17th December 2019

**Application by Norfolk Boreas Limited for the Norfolk Boreas Offshore
Windfarm
Response to Deadline 3
Planning Inspectorate Ref: EN10087
Our Registration ID: 20022672**

We offer the following response to those questions directed at Archaeology and Cultural Heritage as set out within First Written Questions (dated 19th November 2019) and addressed by the Applicant.

Figure 8e

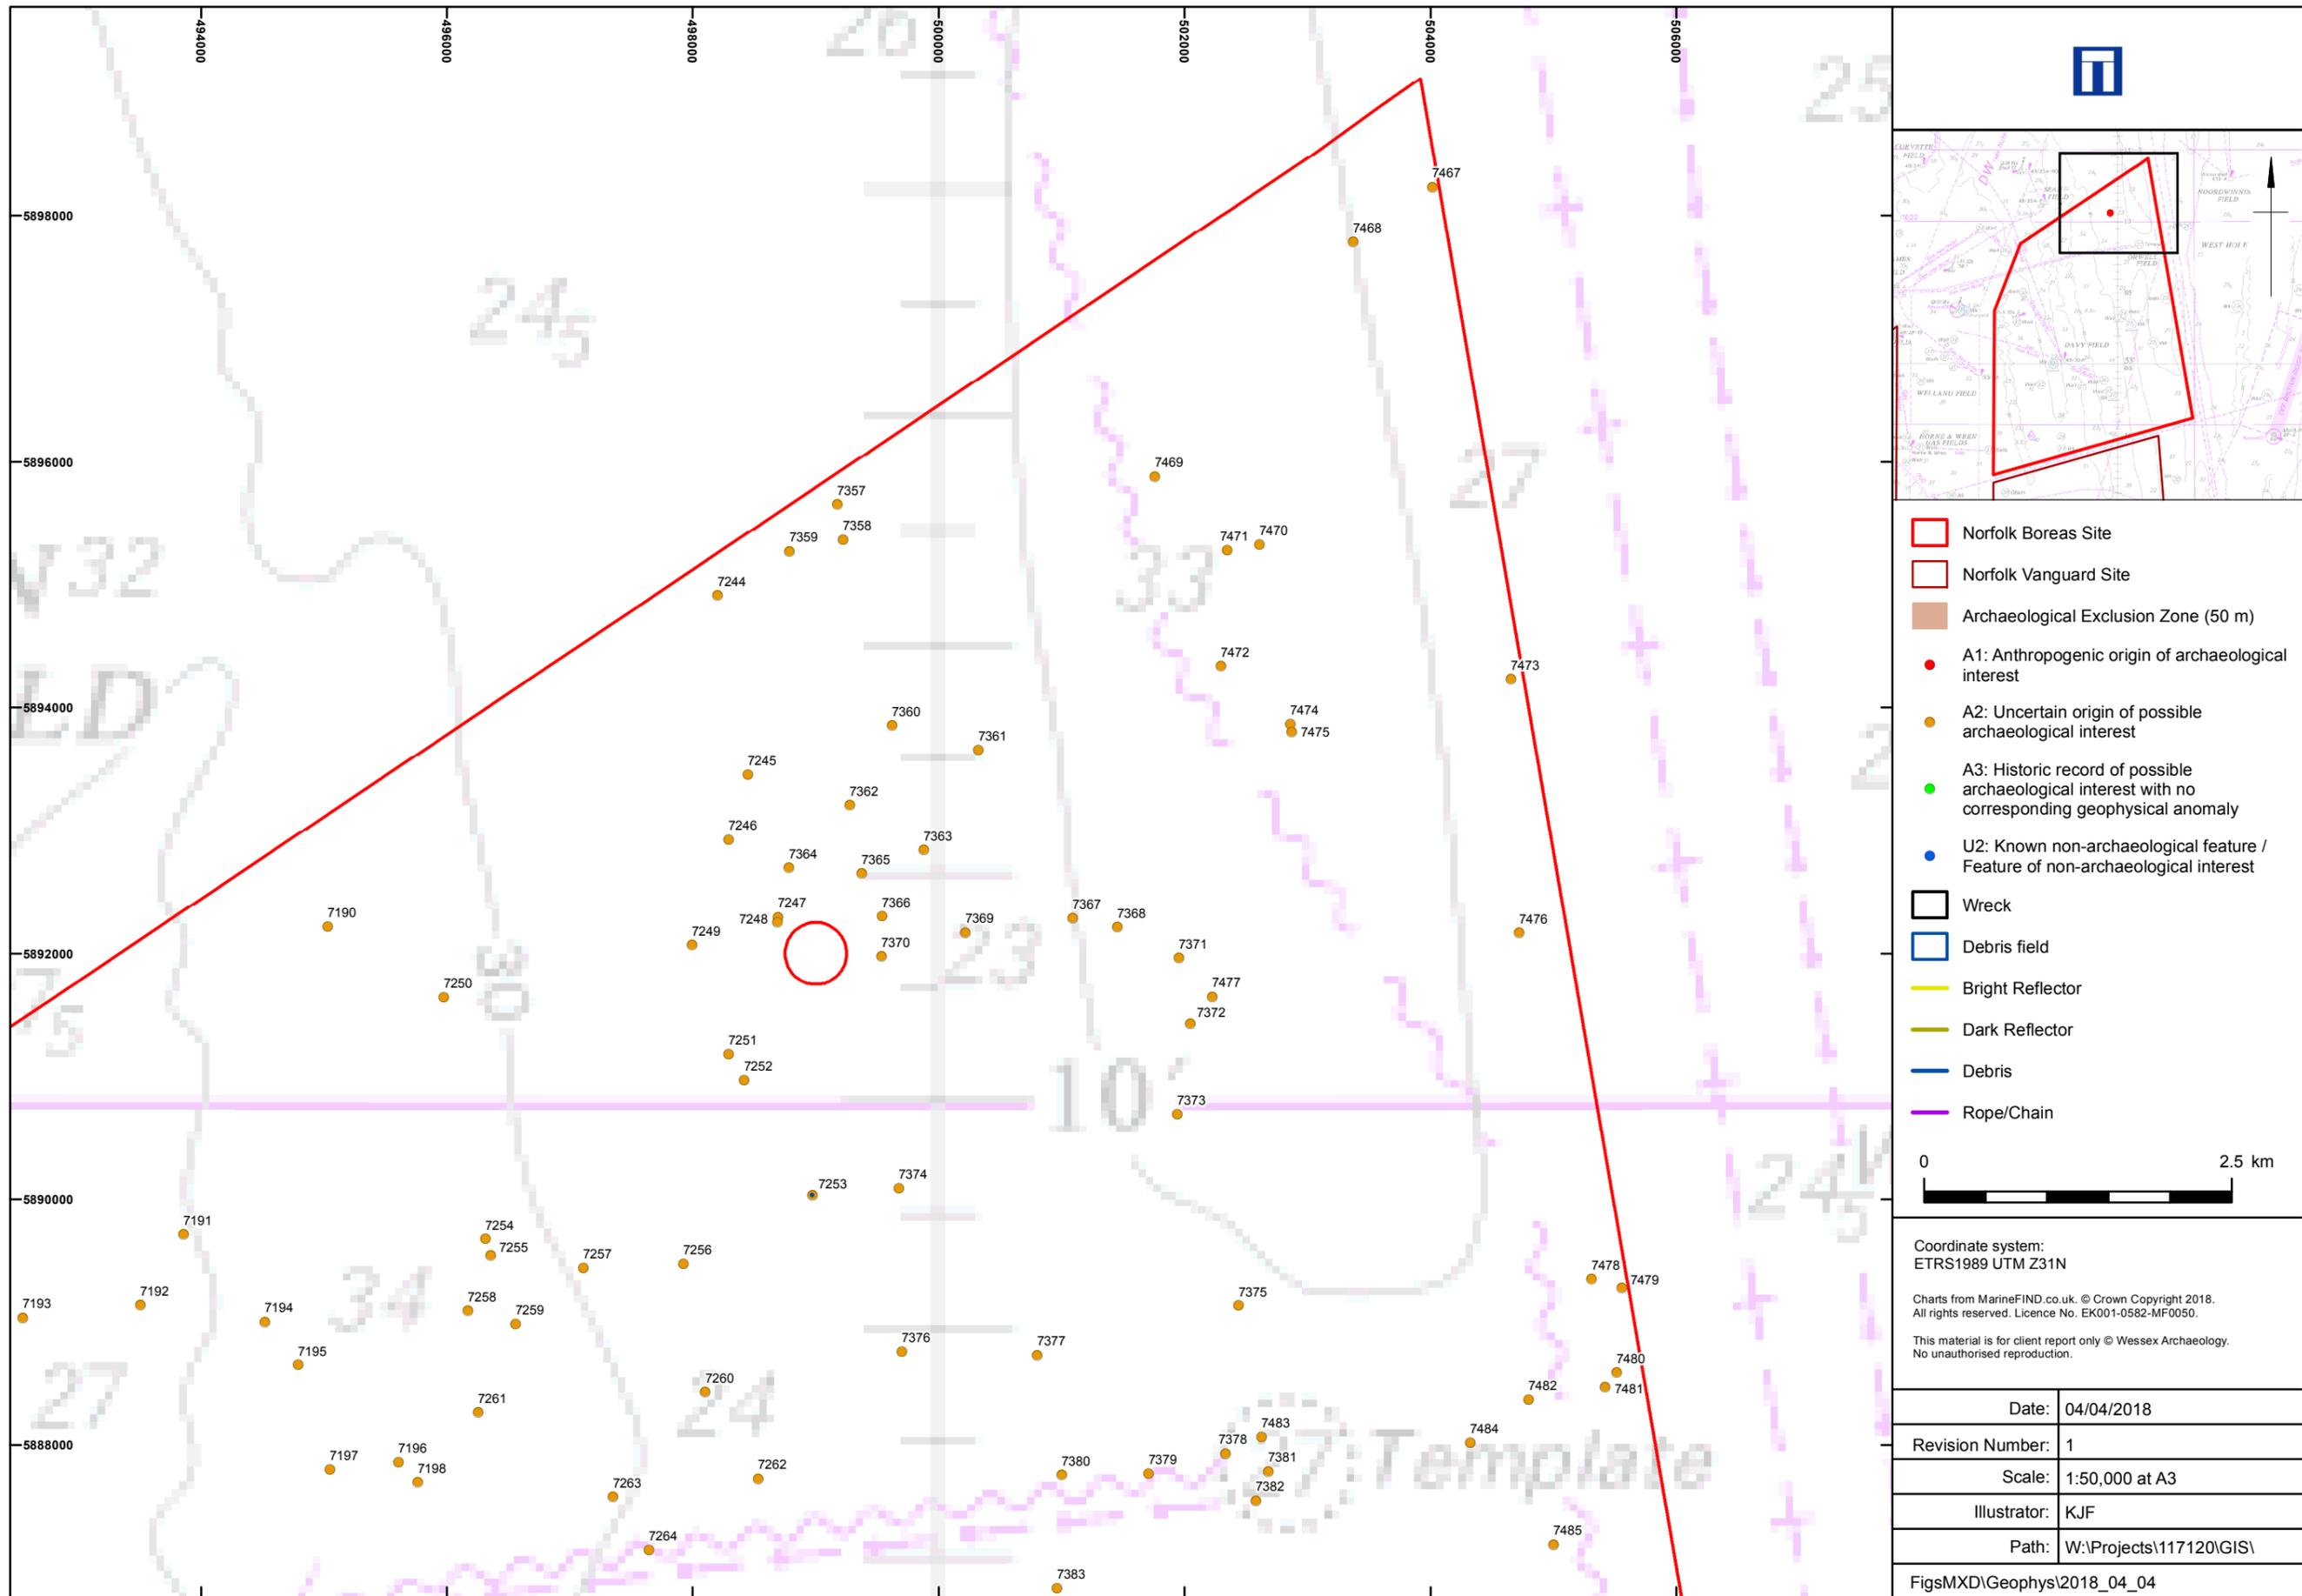
Response: The use of Archaeological Exclusion Zones (AEZs) is in recognition of different seabed development activities and their associated risk to either known or unknown elements of the historic environment as might be present. The primary function in the use of AEZs is as a mitigation measure to provide in-situ protection and therefore the spatial scale of an AEZ will vary on a case-by-case basis. It is therefore important that the archaeological Written Scheme of Investigation (WSI) produced from the outline WSI included within the DCO application explains how AEZs are identified, mapped, monitored and included within other relevant project delivery documentation used by the Consent Holder, contractors and sub-contractors (e.g. *Offshore In Principle Monitoring Plan*, DCO Document: 8.12, version 1, dated June 2019). In reference to the two designated historic shipwreck sites that exist within the proposed development Order Limits:

- The *Seagull* (Feature ID: 70809¹); and
- *Xanthe* (Feature ID: 70834)

It is important to offer the correction to the Applicant's response that these are now scheduled monuments and afforded statutory protection through the provisions of the Ancient Monuments and Archaeological Areas Act 1979. We also confirm that the List Entry for these two designated sites is available, as per the web links provided in our letter, dated 10th December 2019 (response to First Written Questions) submitted for Deadline 2. The List Entry also spatially defines the scheduled area, for both these designated heritage assets, as 100m in radius and therefore the minimum spatial extent of any AEZ must be amended to accordingly within any offshore archaeological WSI produced post-consent, should permission be obtained.
